Application by North Falls Offshore Wind Farm Ltd for North Falls Offshore Wind Farm

The Examining Authority's written questions and requests for information (ExQ3)

Issued on 1 July 2025

LUC		www.landuse.co.uk	
Project North Falls Onshore Substation			
Client North Falls			
LUC Job No 12155		Scale @A1 1:500	Status S0
Drawing Title Landscape Sections Sheet 2 of 6			
Drawing No 12155-LUC-00-VS-L-0002		Rev A

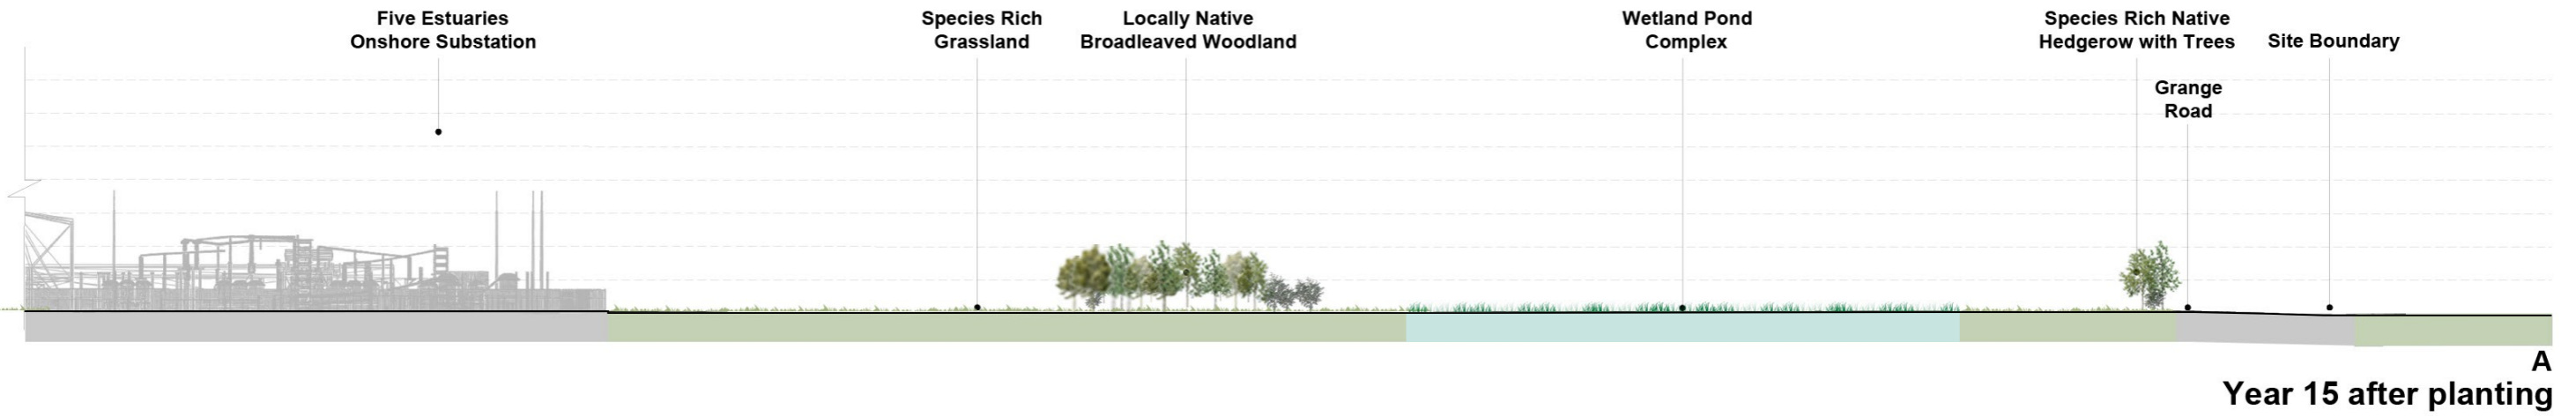
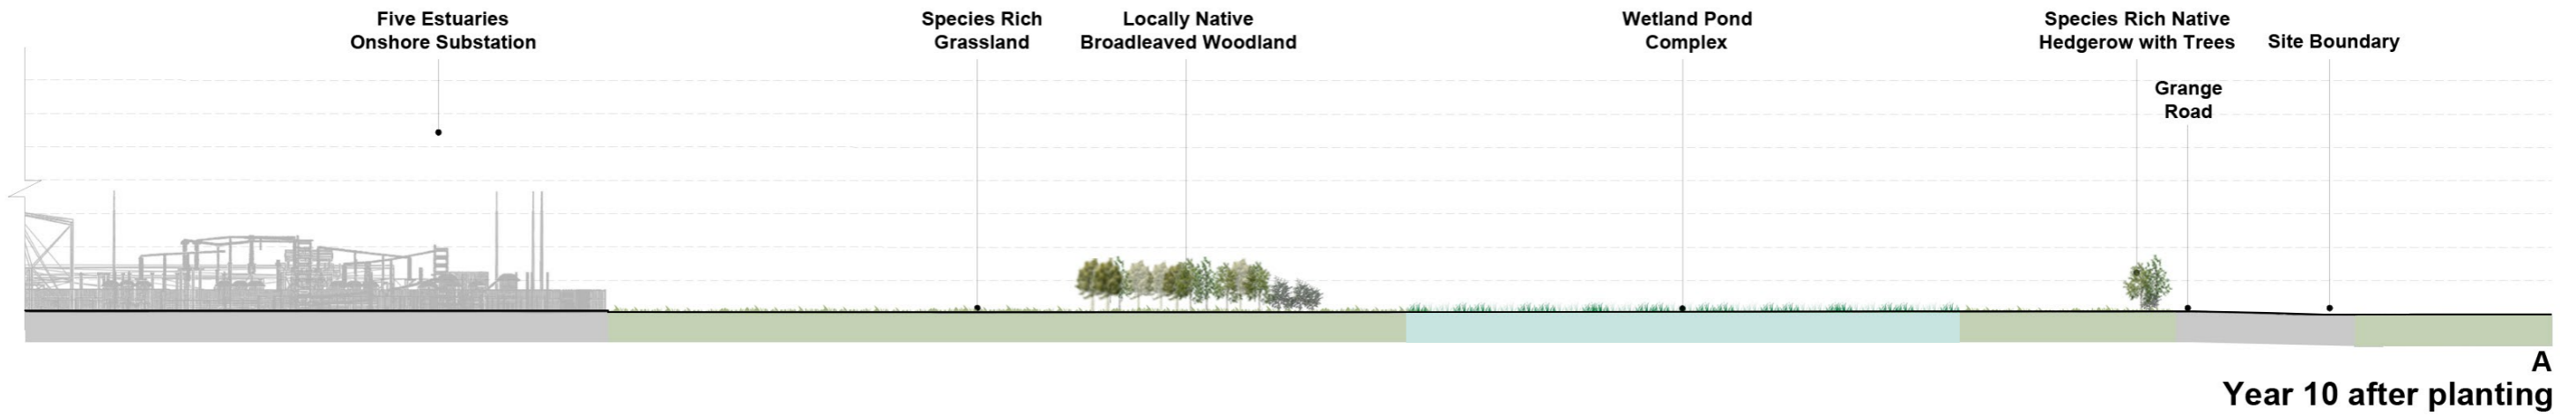
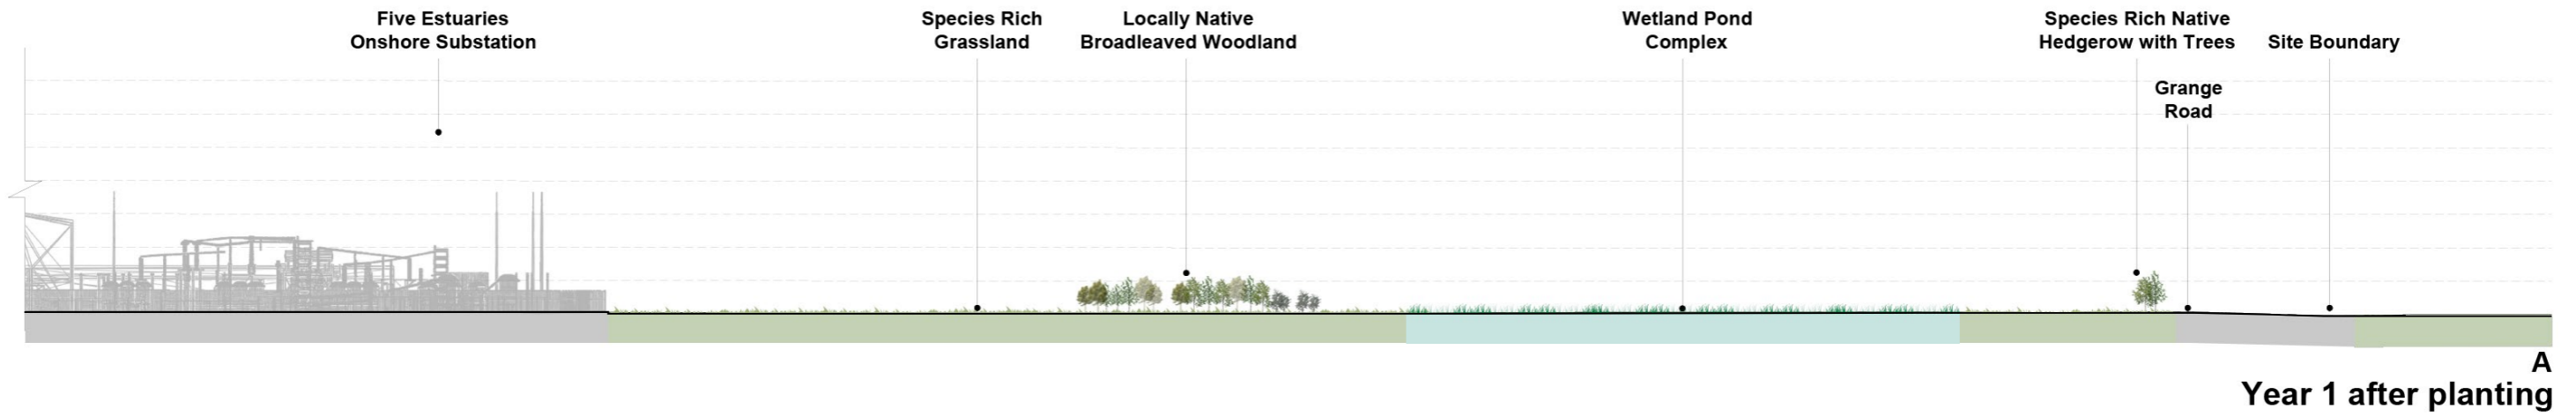
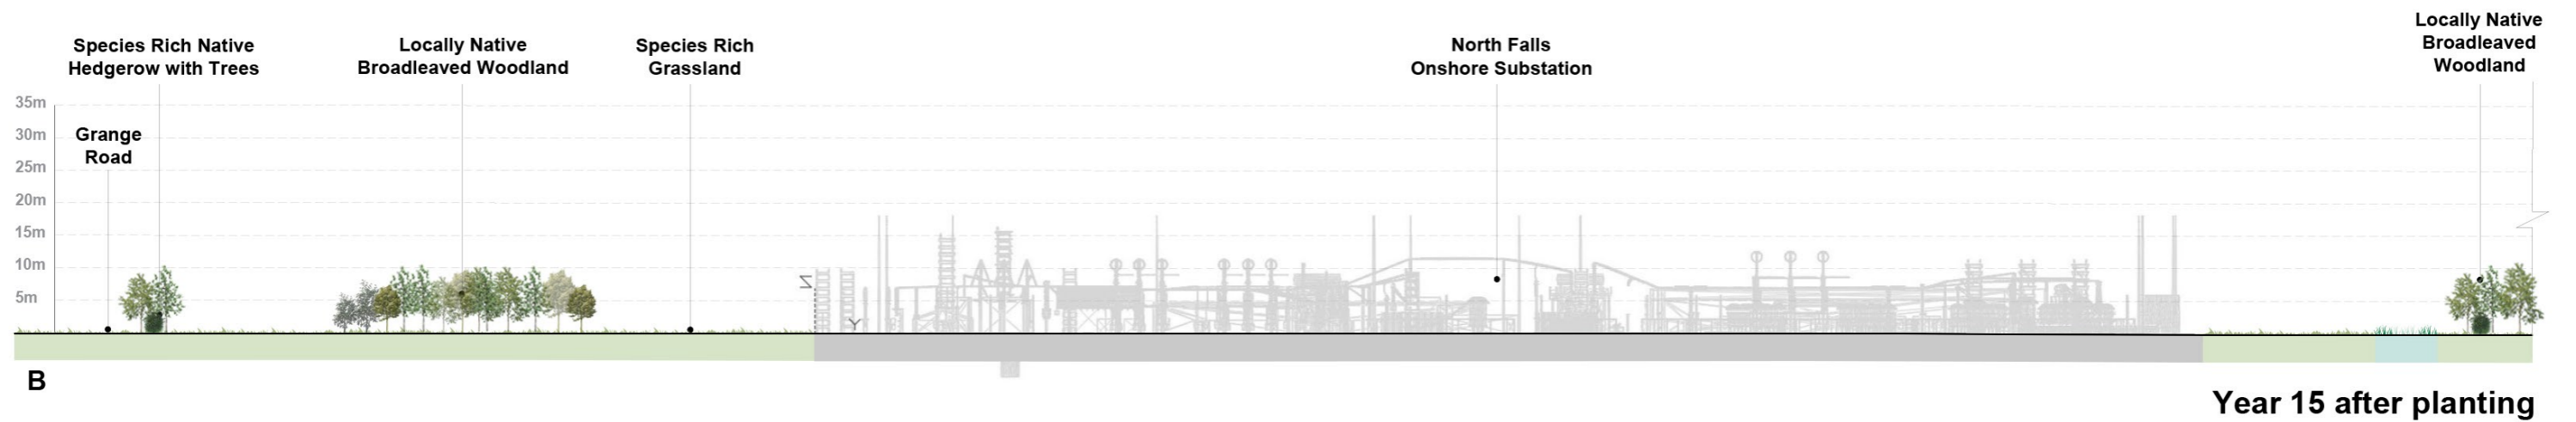
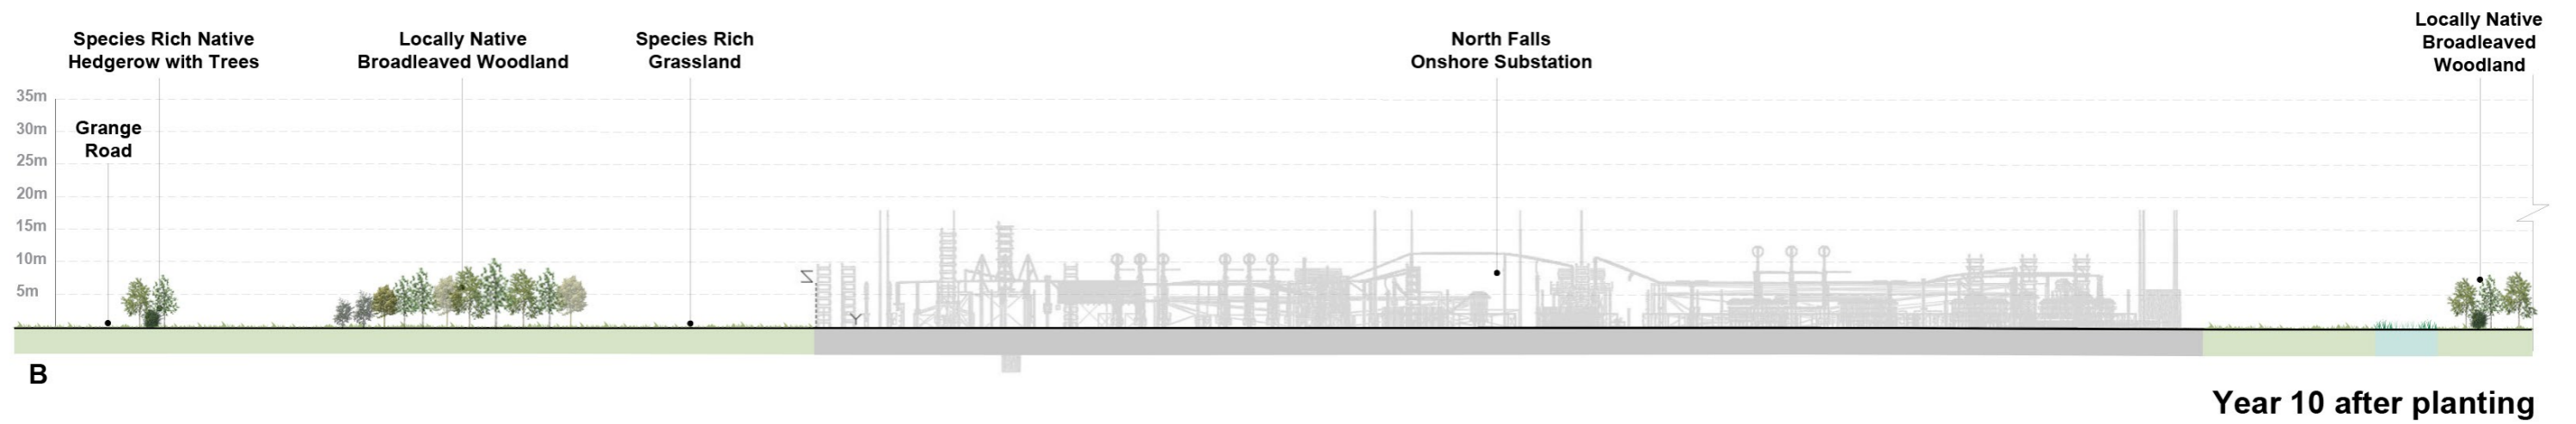
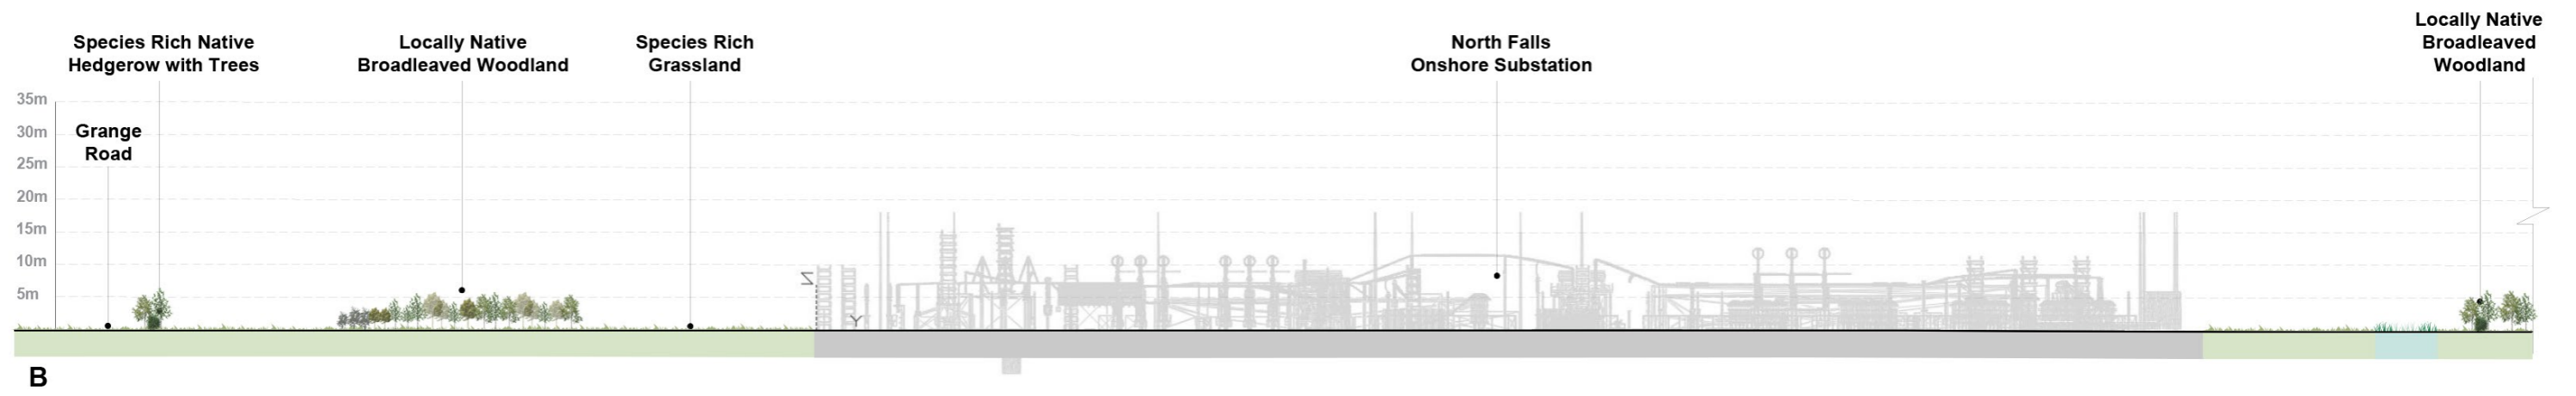
ExQ2	Question to:	Question:
Q14.0.1	Applicant	<p>Visual Mitigation at Substation</p> <p>The ExA notes the update to 9.30 Indicative Planting cross-sections at the onshore substation (Rev 2) [REP5-035] at Deadline 5. This confirms that planting would not be orchard planting but a series of woodland belts.</p> <p>i) Please can the Applicant elaborate, setting out timescales to maturity and at what point the screening will have taken full effect.</p> <p>ii) With regard to the Written Landscape Scheme, could the OLEMS clarify the details of trees, woodland and hedgerows, finished ground levels and bunding, and plant details including, where possible plant schedule will also be provided as drawings to illustrate the written details. Could boundary treatments also be included on the drawings for clarity.</p>
Q14.0.2	Applicant	<p>Screening at Substation: VEOF</p> <p>REP4-038 (10.20.8 Technical Note - Screen planting options for Land Plot 17-024) submitted to the VEOF Examination (see [REP4-038]) provides indicative cross sections to illustrate the potential mix of screening planting, as well as how this might mature over 5, 10 and 20 years. The planted woodland areas would screen the onshore substation, and provide a landscape feature. Please can the Applicant provide commentary on principle differences between the VEOF proposals and those of NFOWF, and what further steps can be taken to align them.</p>
